Please ask for: Ms Iqraa Malik
Email: iqraa.malik@terraquest.co.uk
Telephone: 01212341390
Our Ref: A/76/21/HH
Your Ref:
Date: 22nd April 2021

Application for Planning Permission for Works or Extension to a Dwelling

Development: Erection of single storey rear extension
Location: Fairhaven North Drive Angmering BN16 4JJ

Disc	PLANNING	Scale	1:50, 100, 500 & 1250 @ A1	Disc Ref	102
Date	APRIL '21			Drawing Number	AL-100a

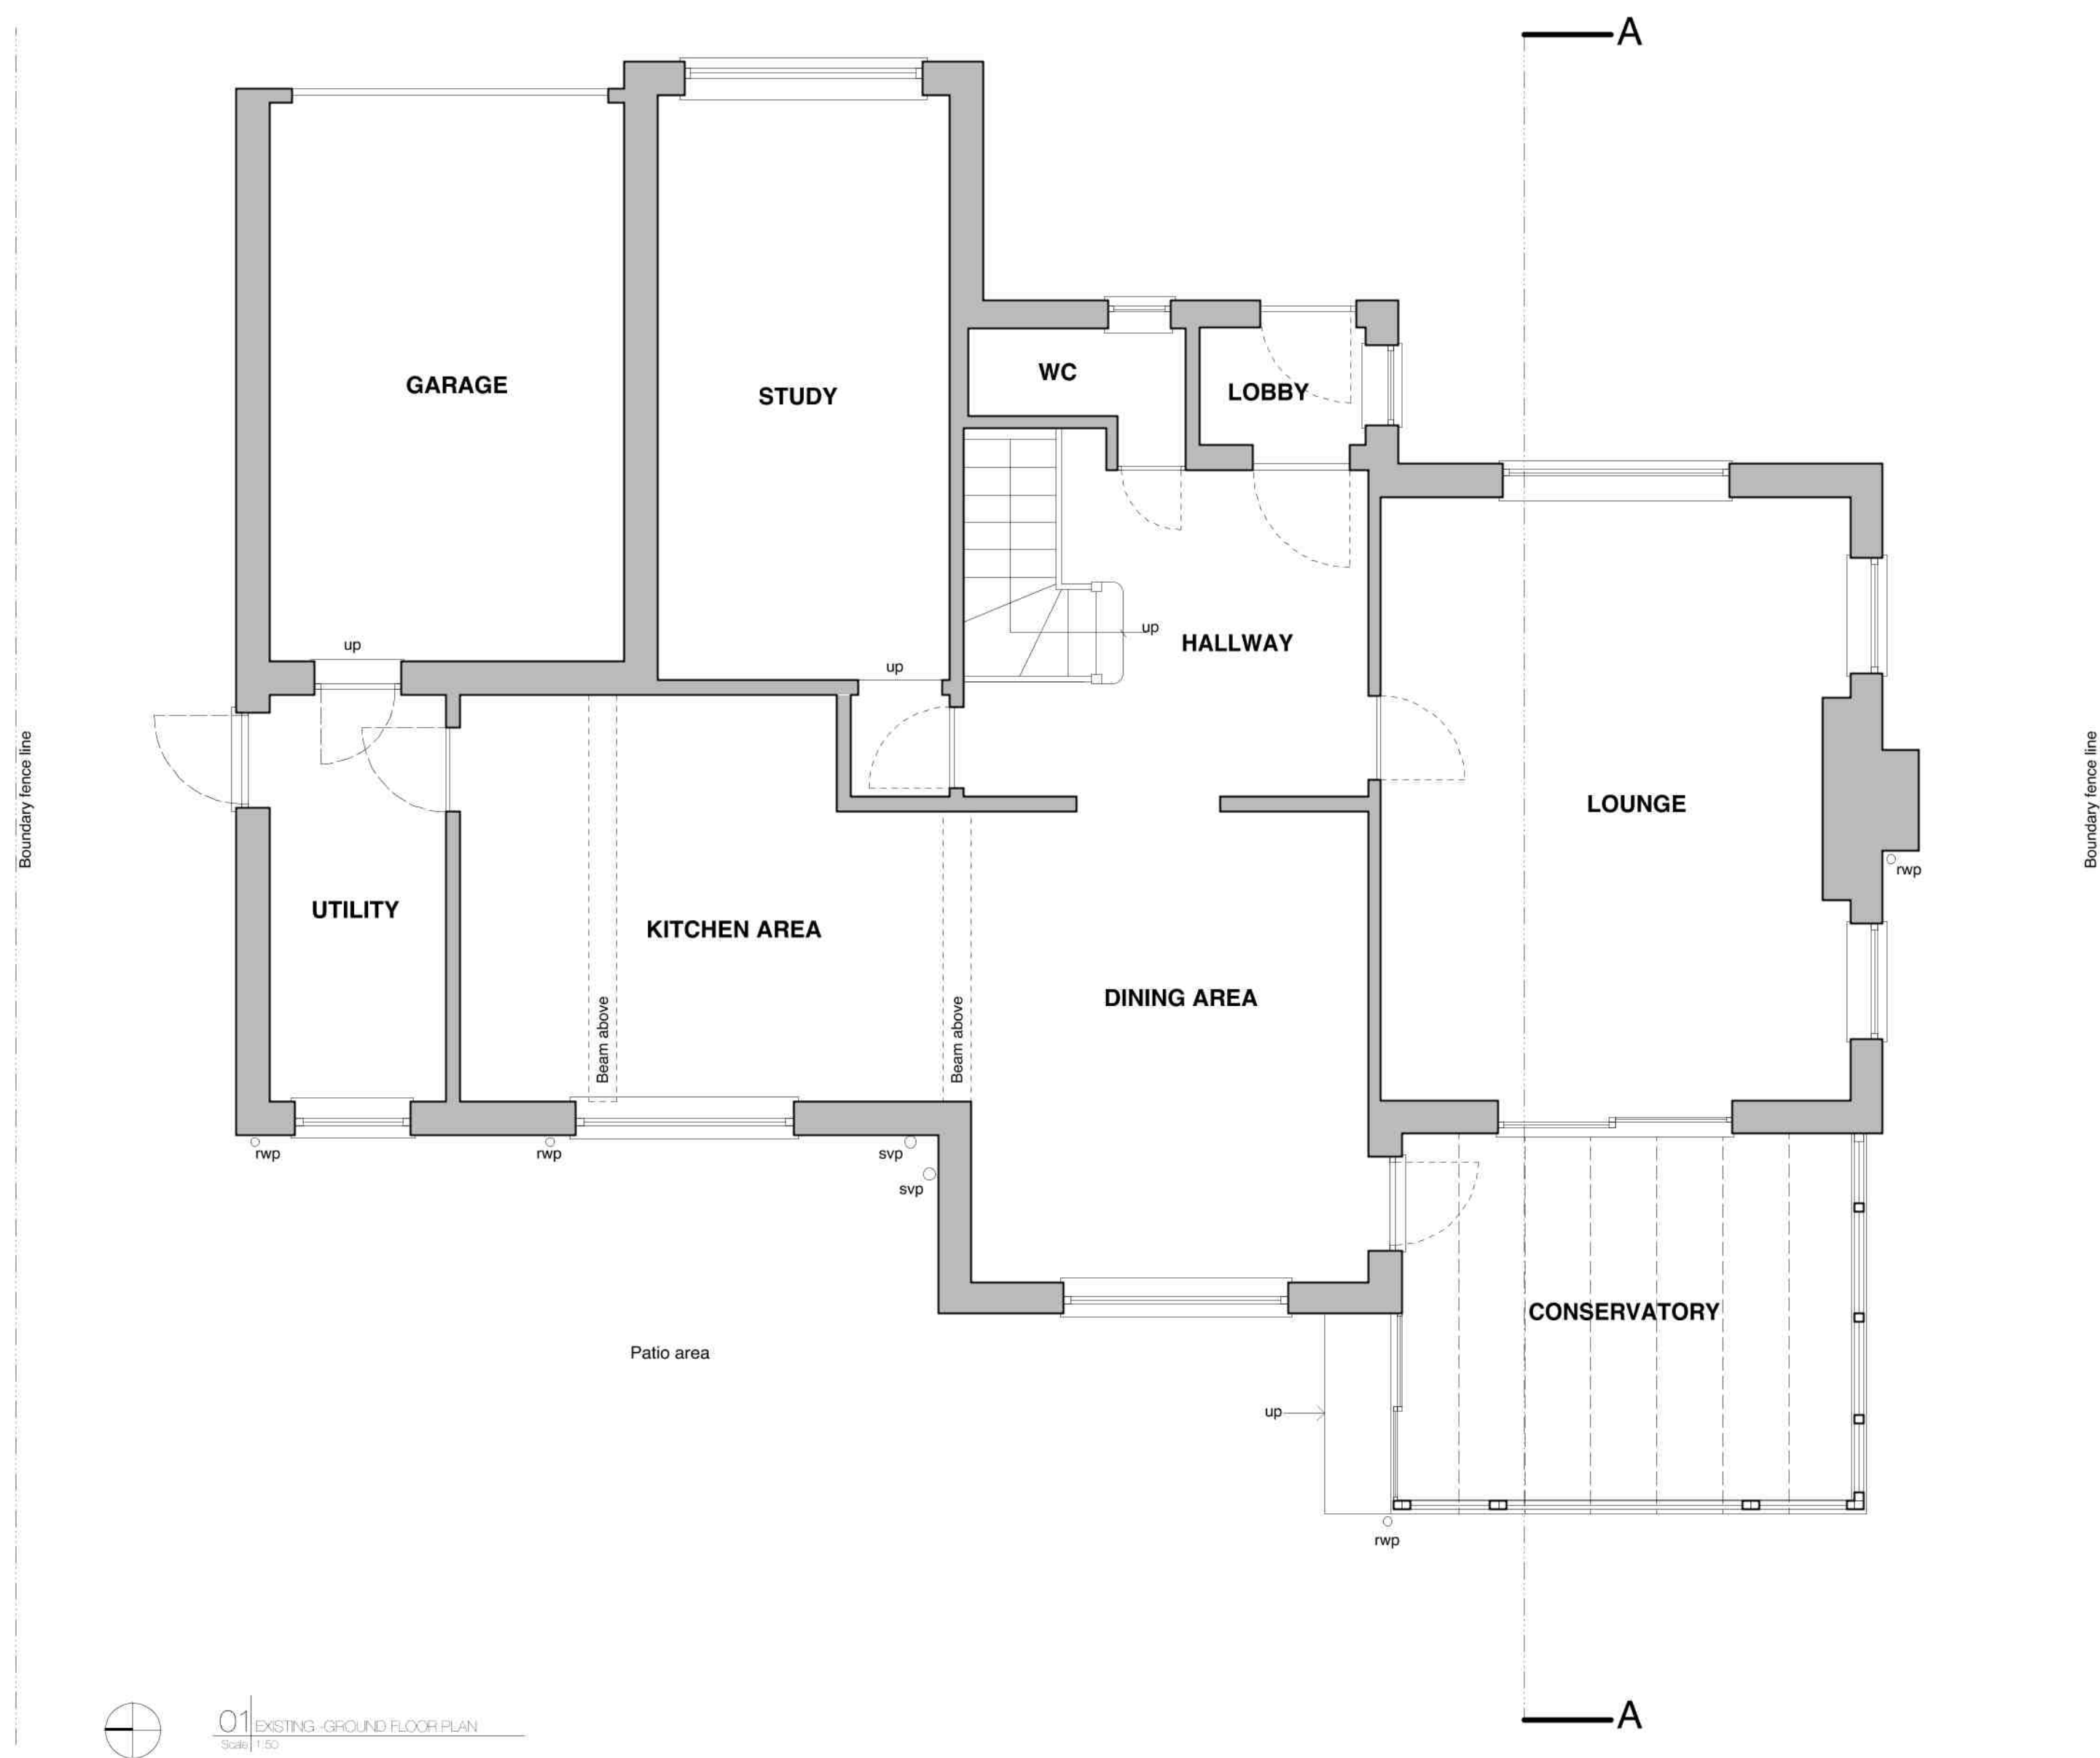
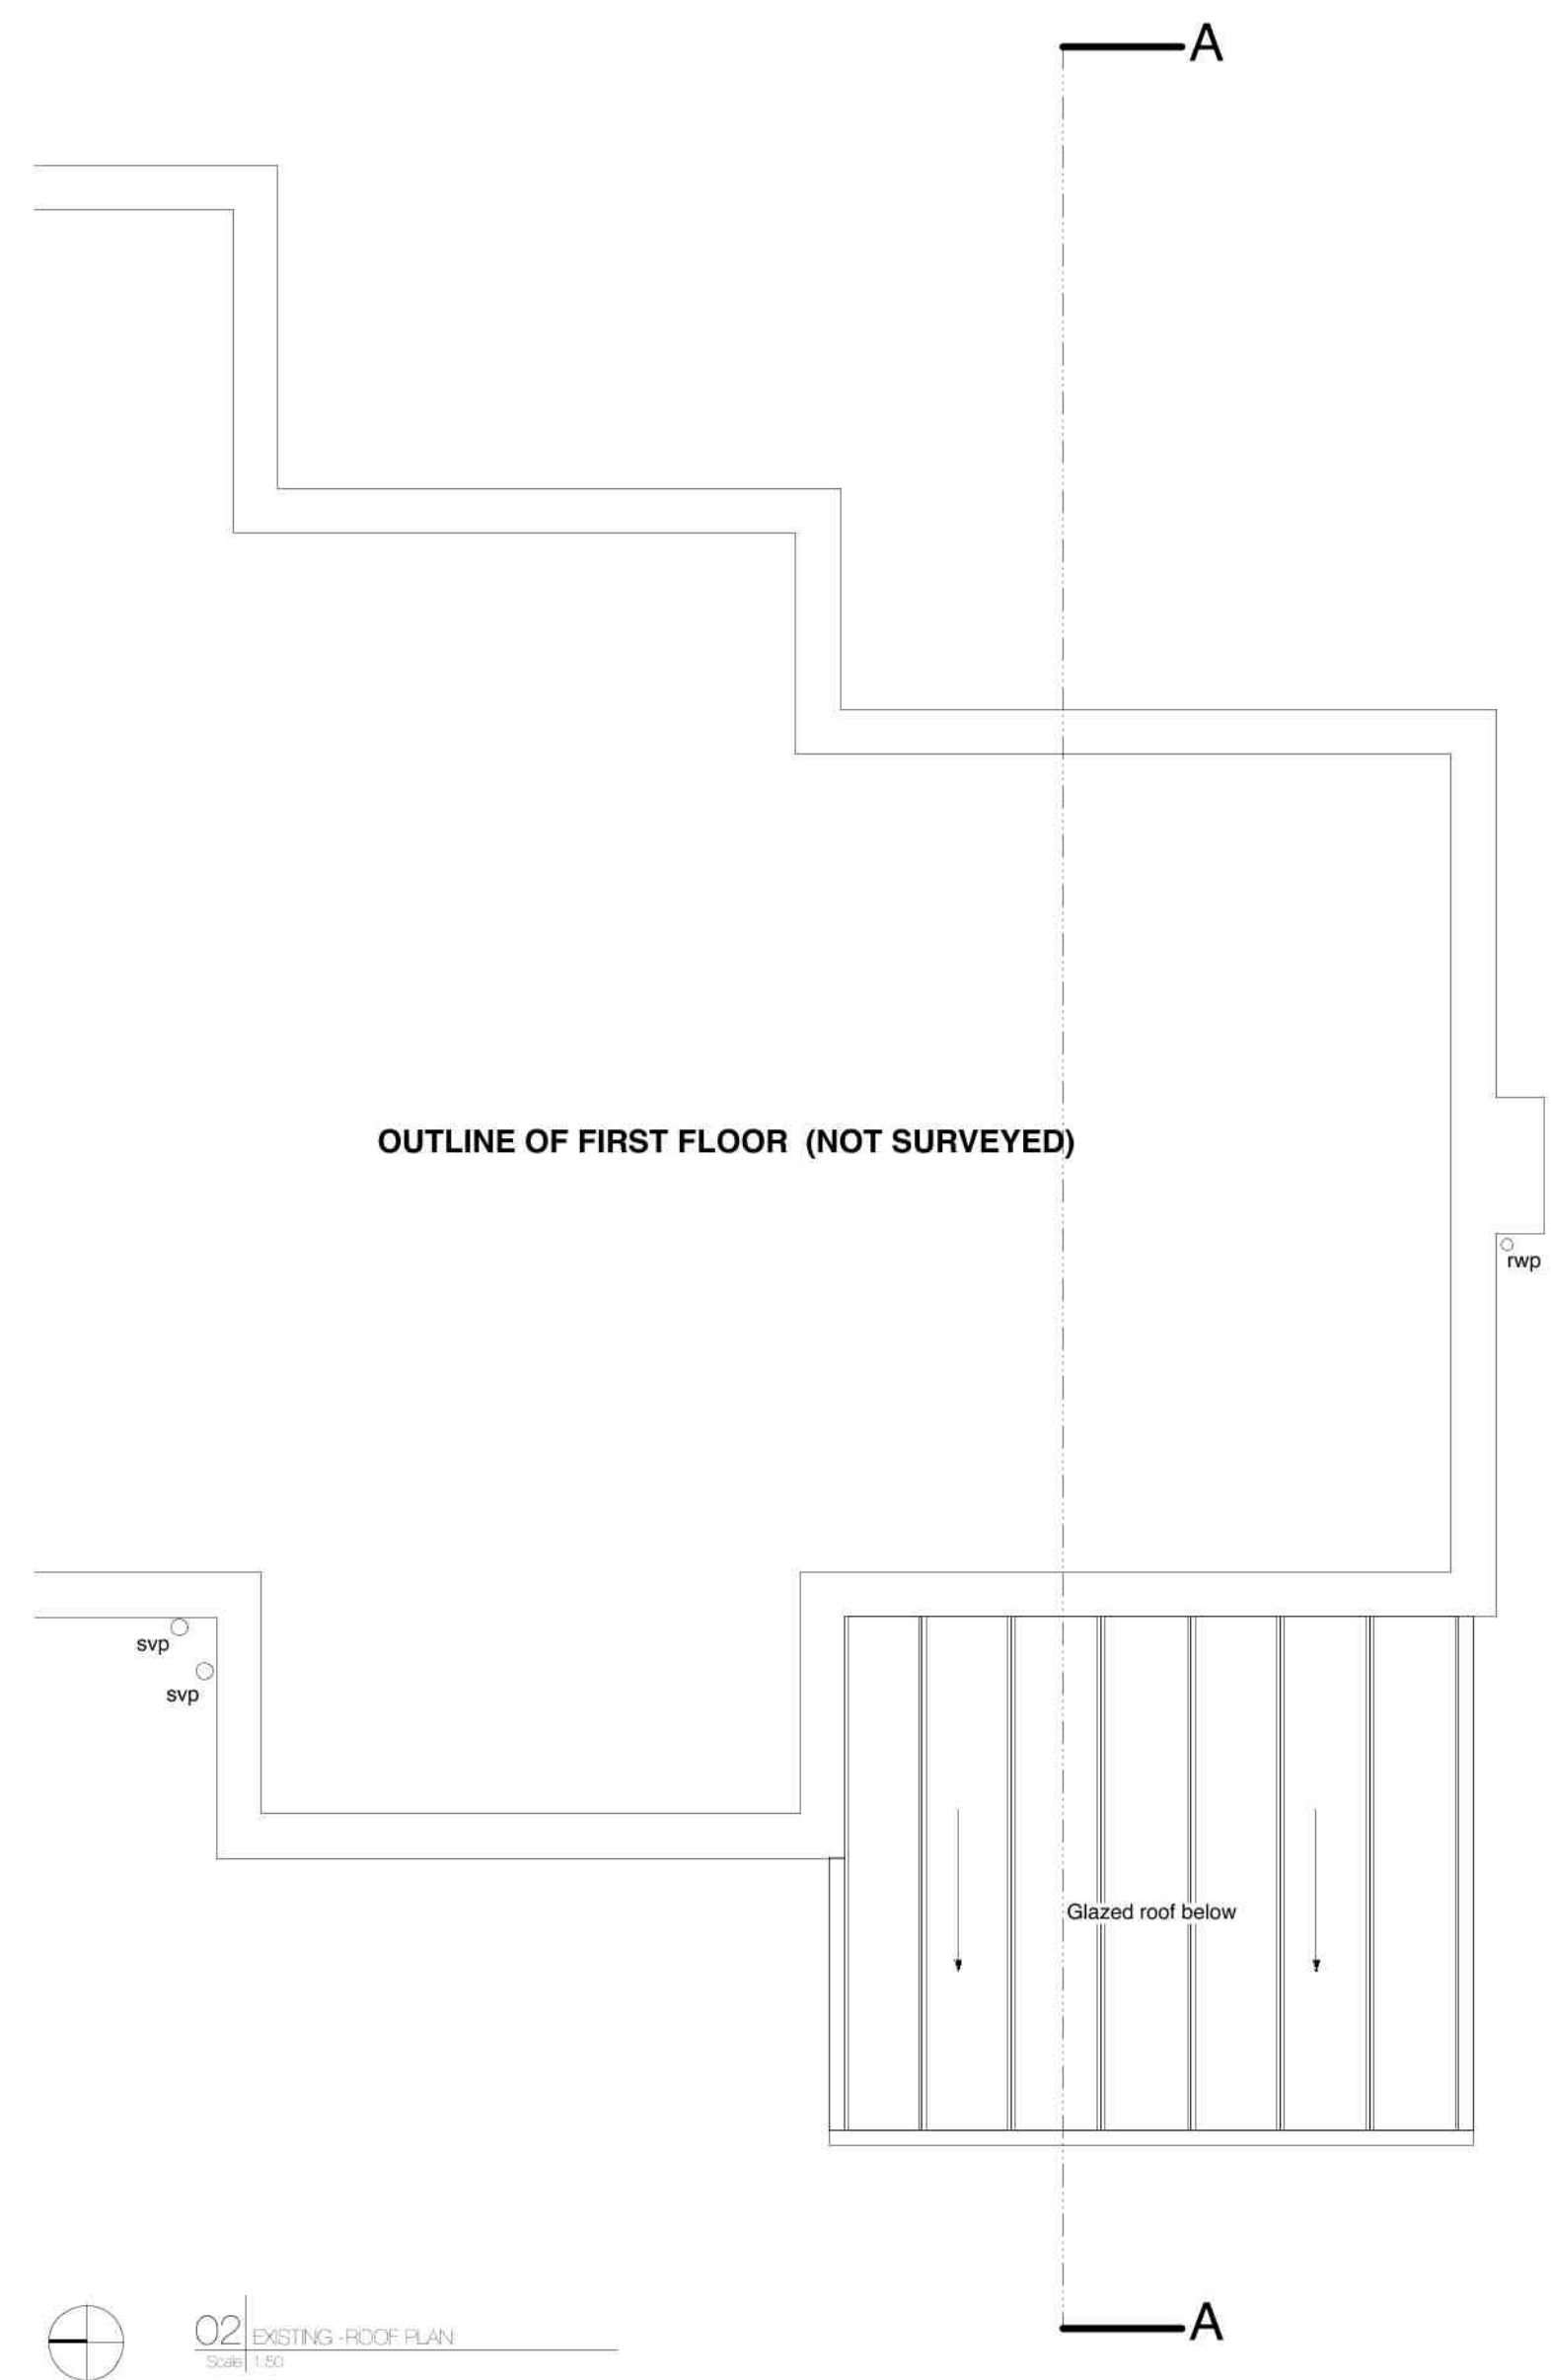
You are required to have dimensions from the proposed extension(s) to all site boundaries. Please amend

The lobby window on the existing and proposed floor plan is missing from the existing and proposed side elevation. Please review and amend accordingly.
